## Appendix A – Detailed record and response to submissions and additional information

Extracts from Government agency and authority submissions received in relation to SSD 10479, and a response to each of these matters, has been outlined in the table below.

36.5m B-TRIPLE TURNING PATH PLAN
1 : 250

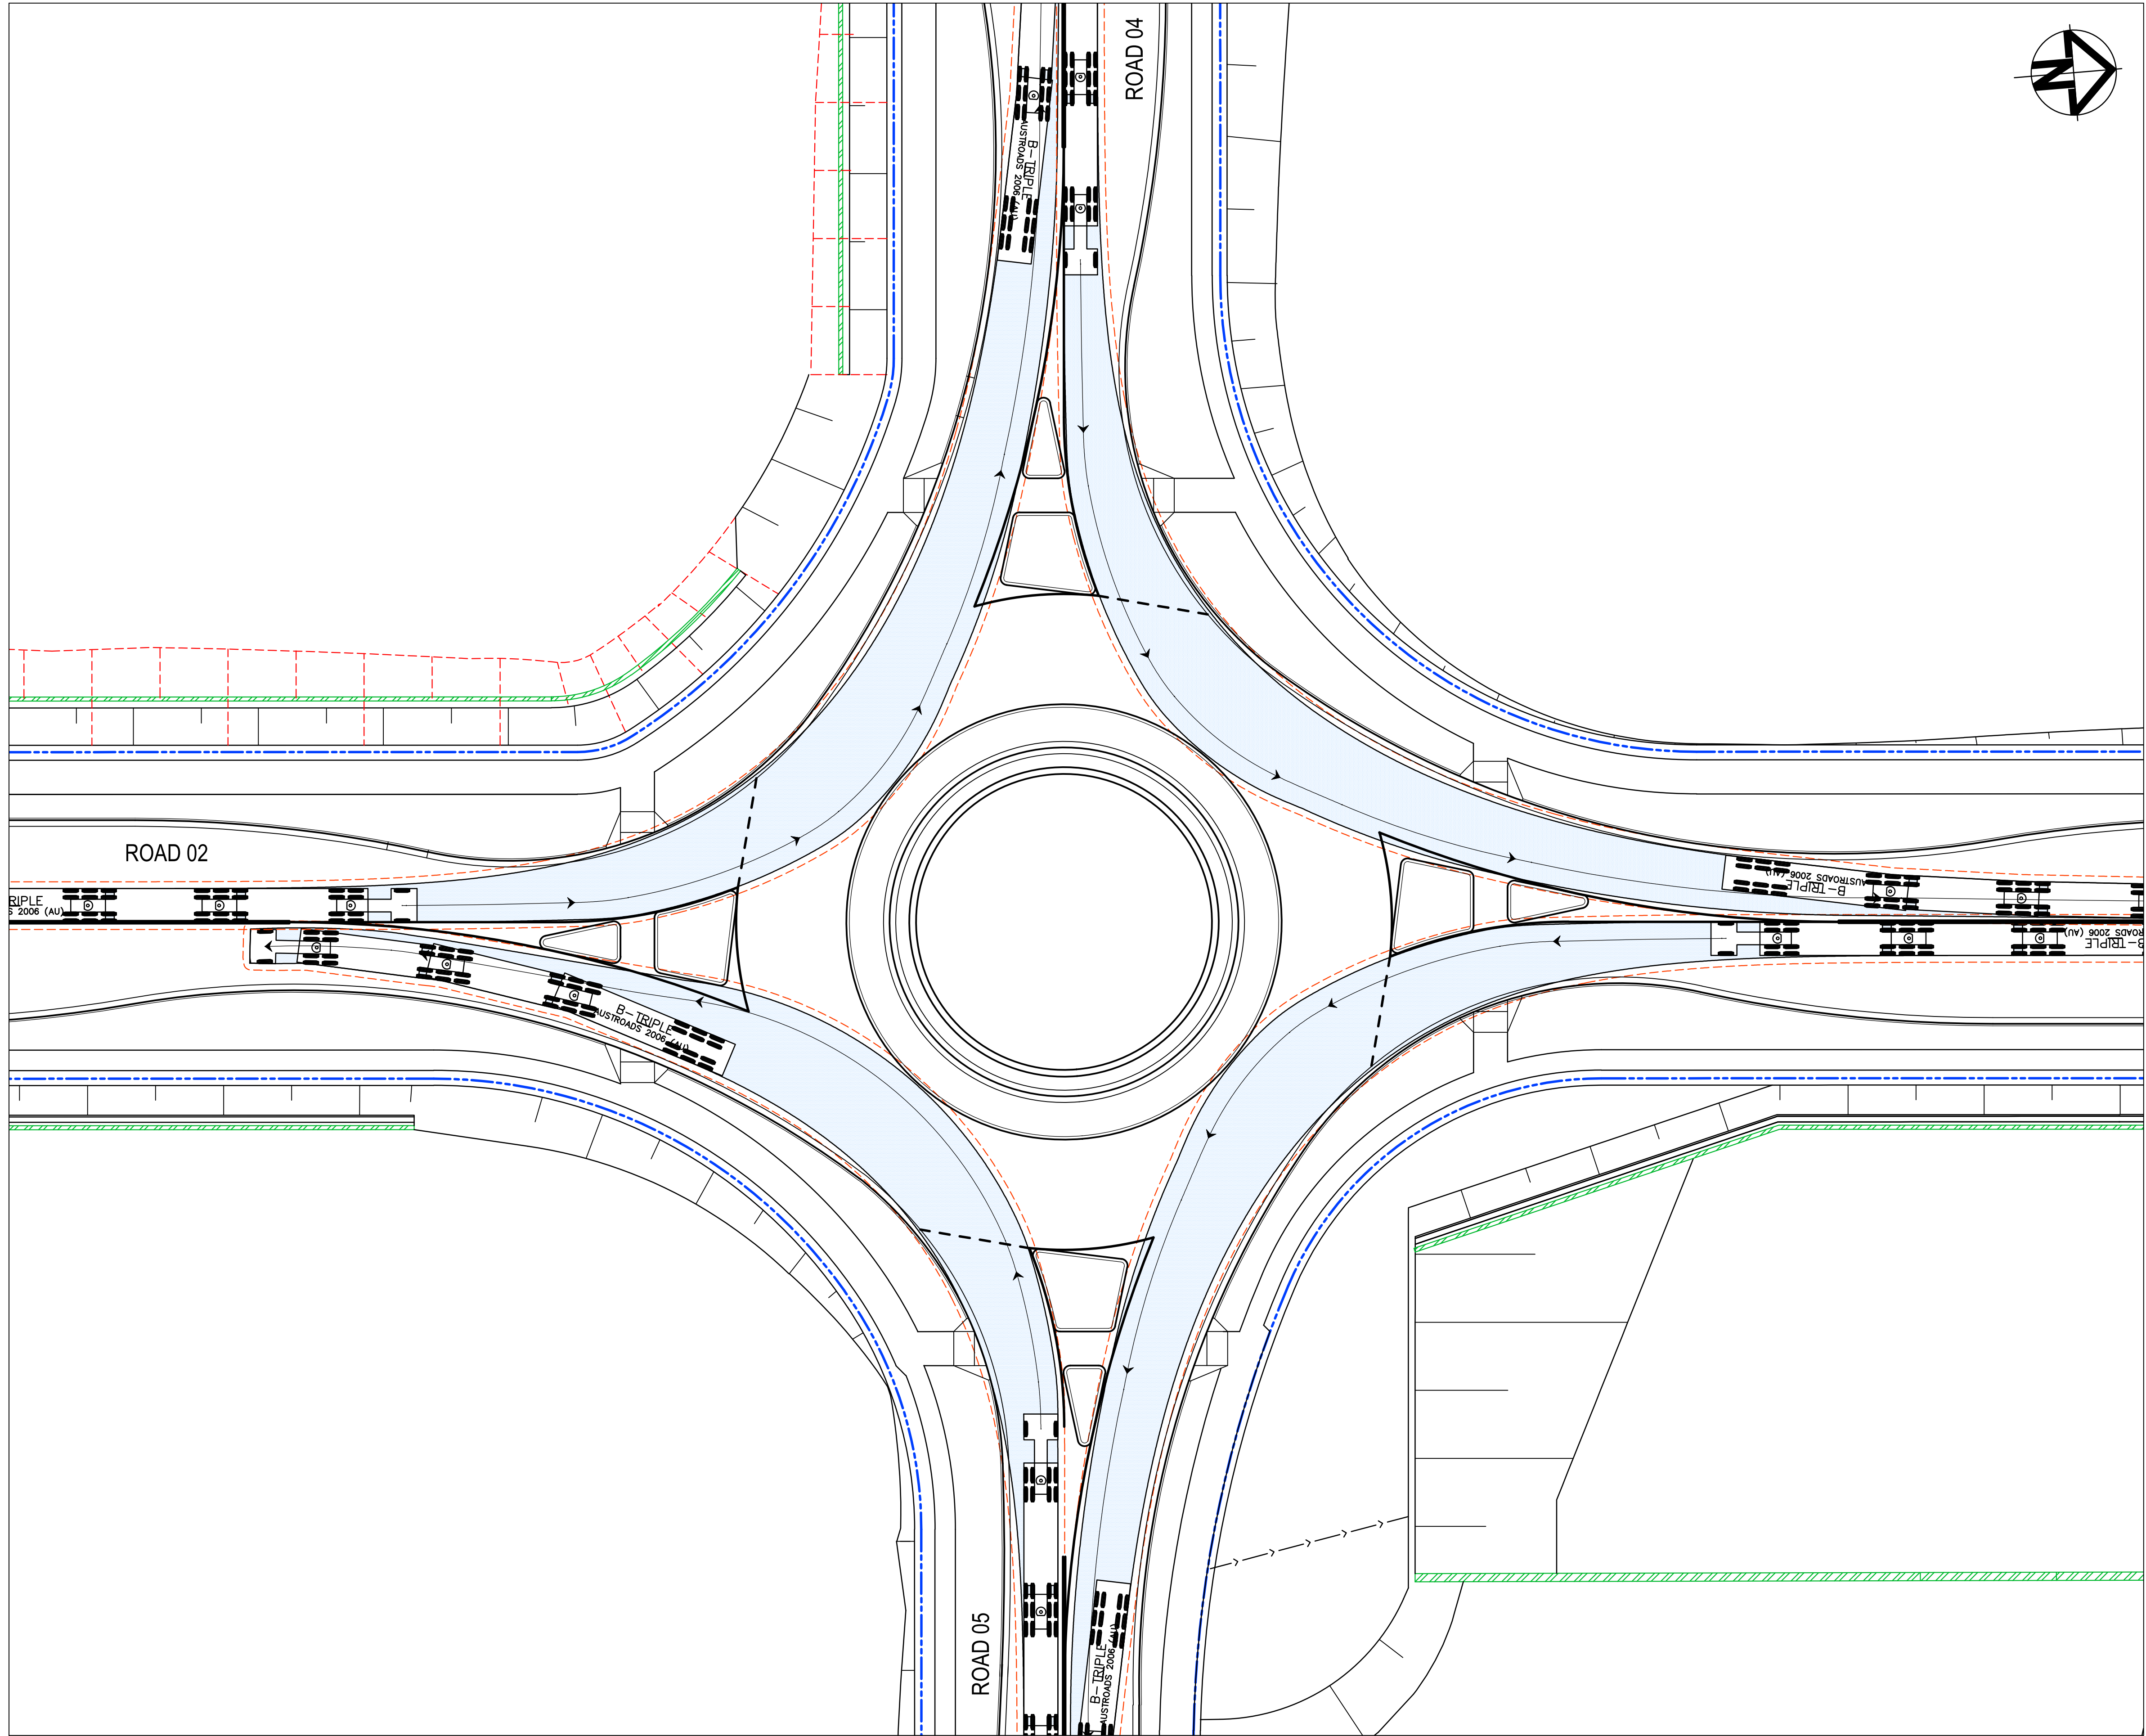
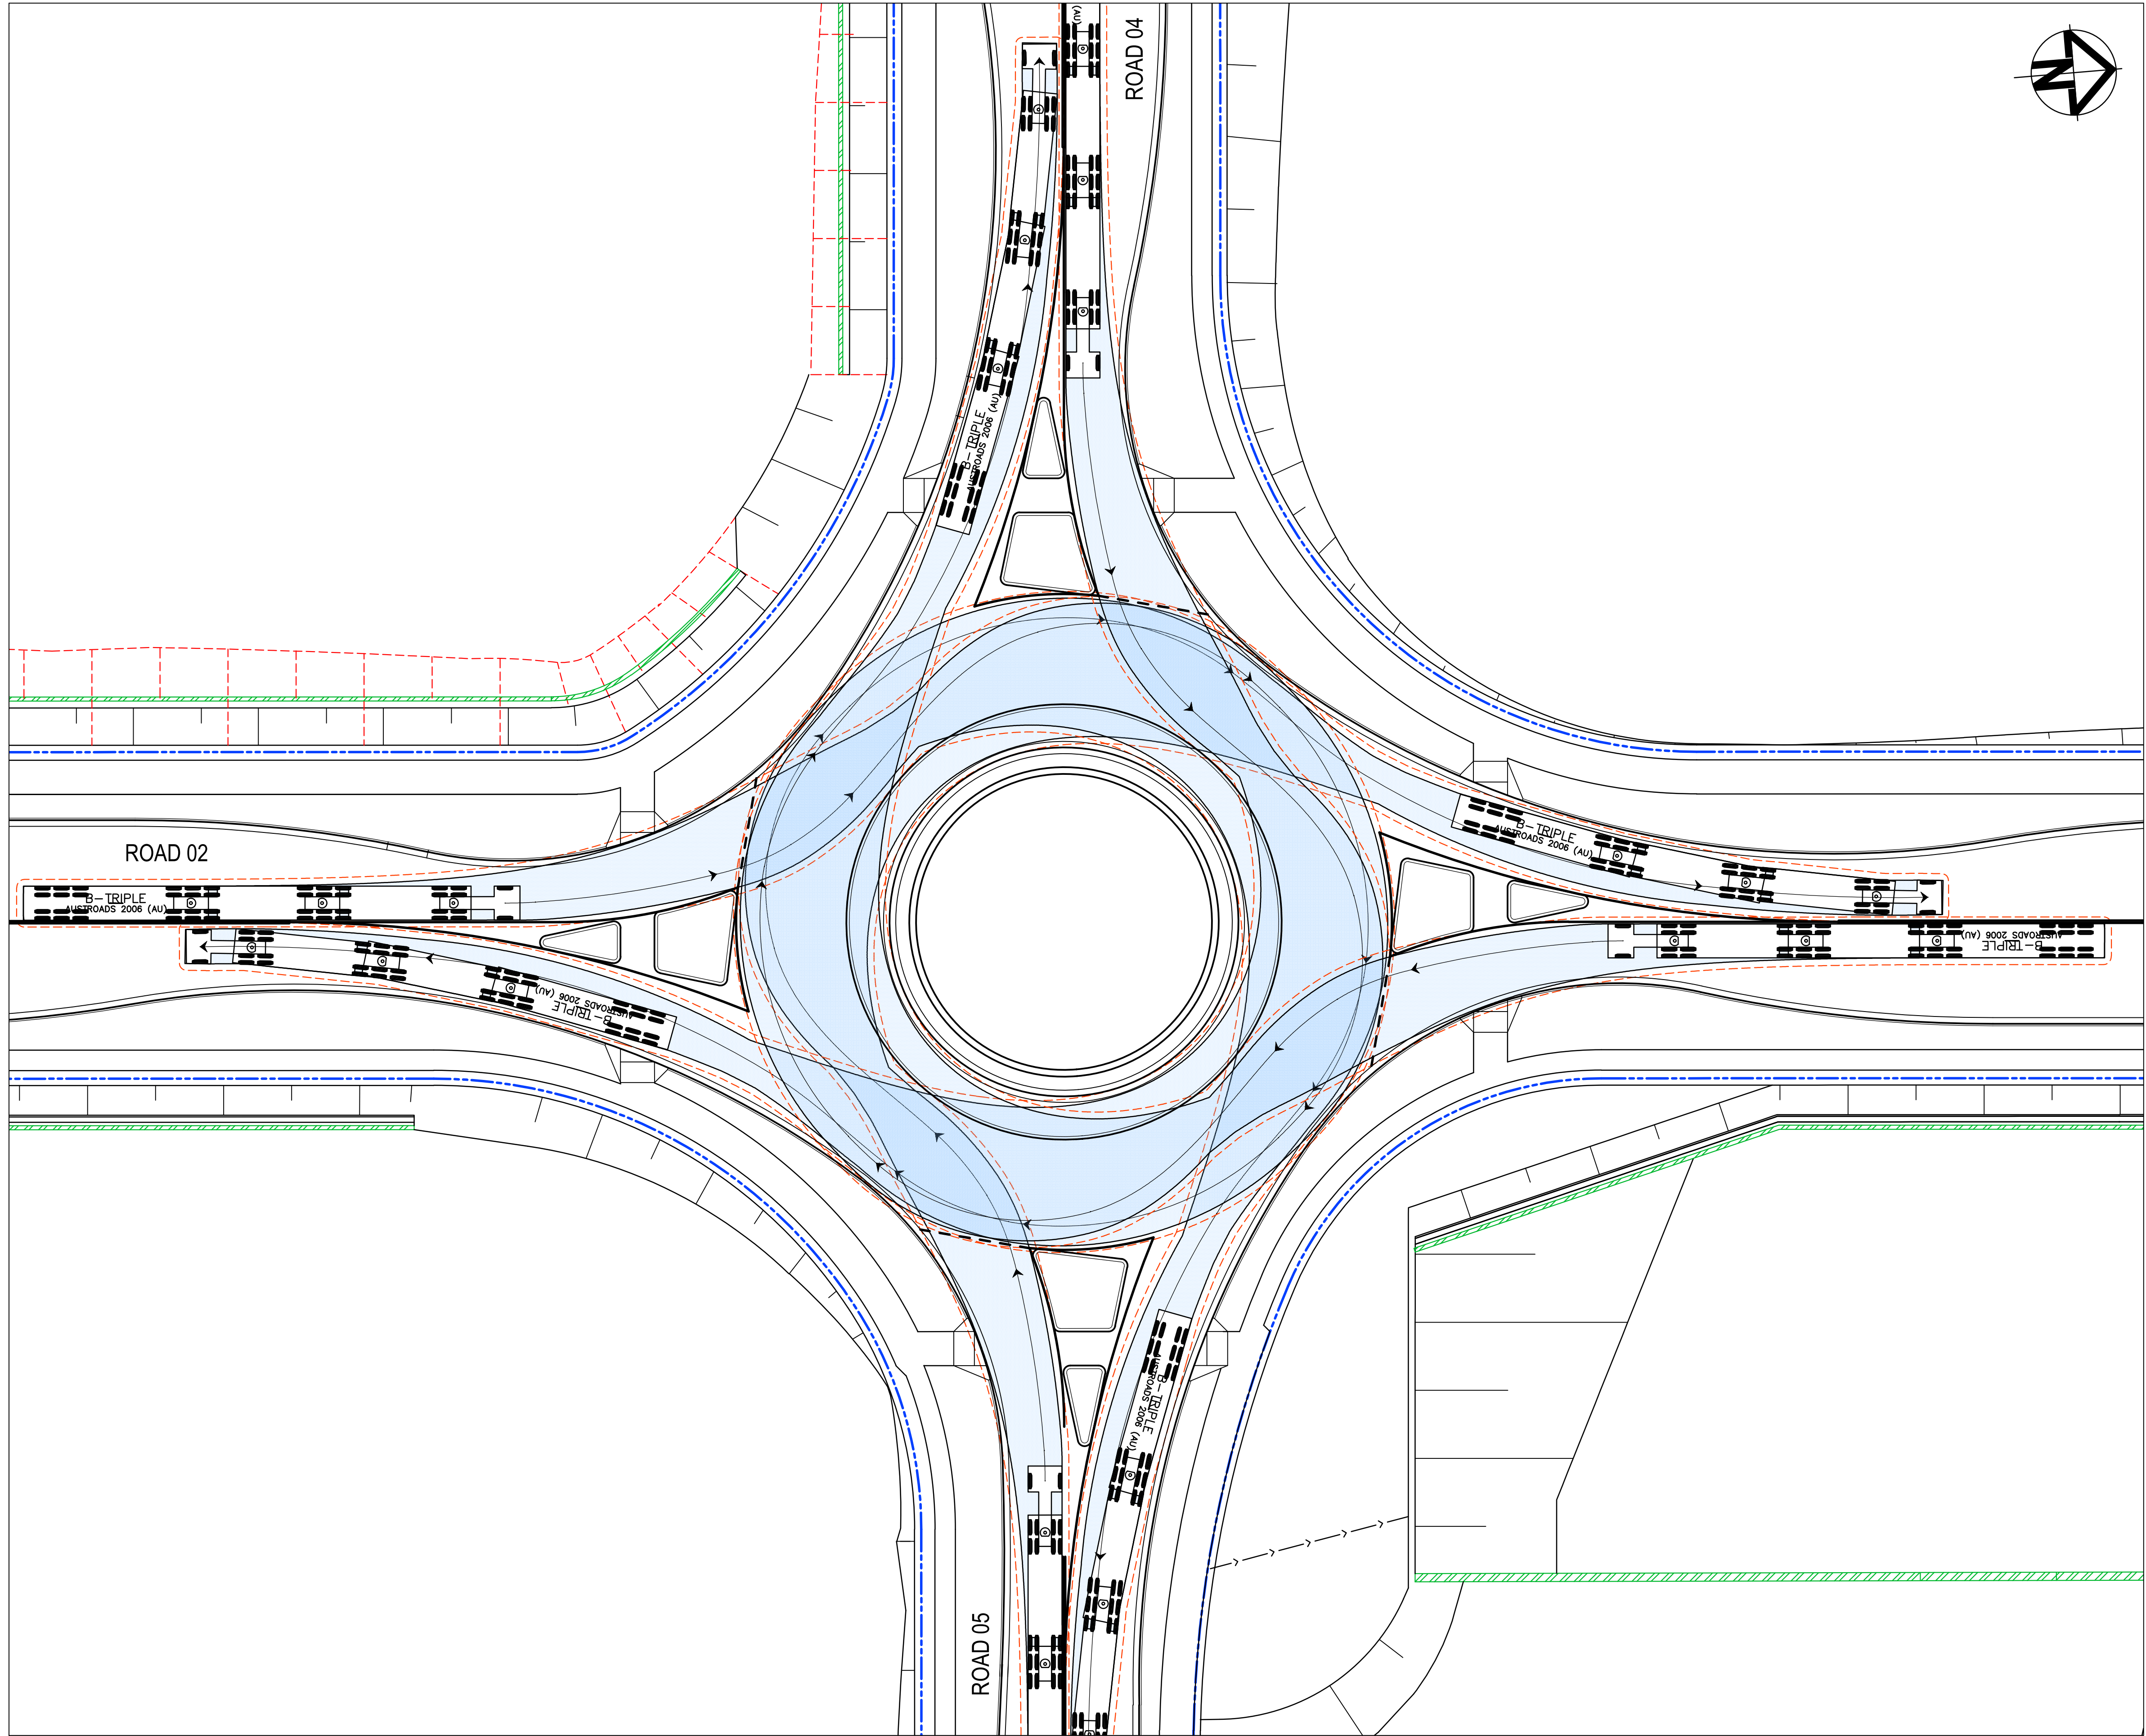
<p>Appendix Z - Civil Drawings - Intersection (1) &amp; (2) – Turning path plans are provided for 30m PBS type 2B. According to the Draft Mamre Road Precinct DCP Road design item (16), it should be tested for 36.5m PBS Level 3 type A vehicles.</p>	
<p>TfNSW requests the abovementioned information to be addressed/provided for further assessment prior to the determination of the application. TfNSW will further review and provide response upon receipt of the additional information</p>	
<p>TfNSW notes that the applicant has provided a Framework Sustainable Travel Plan. In their previous submission TfNSW advised that the applicant prepare a Green Travel Plan in consultation with TfNSW for the warehouse and ancillary office buildings proposed for Lot F. The applicant shall submit a copy of the final plan to TfNSW for endorsement prior to the issue of the first occupation certificate</p>	Noted.
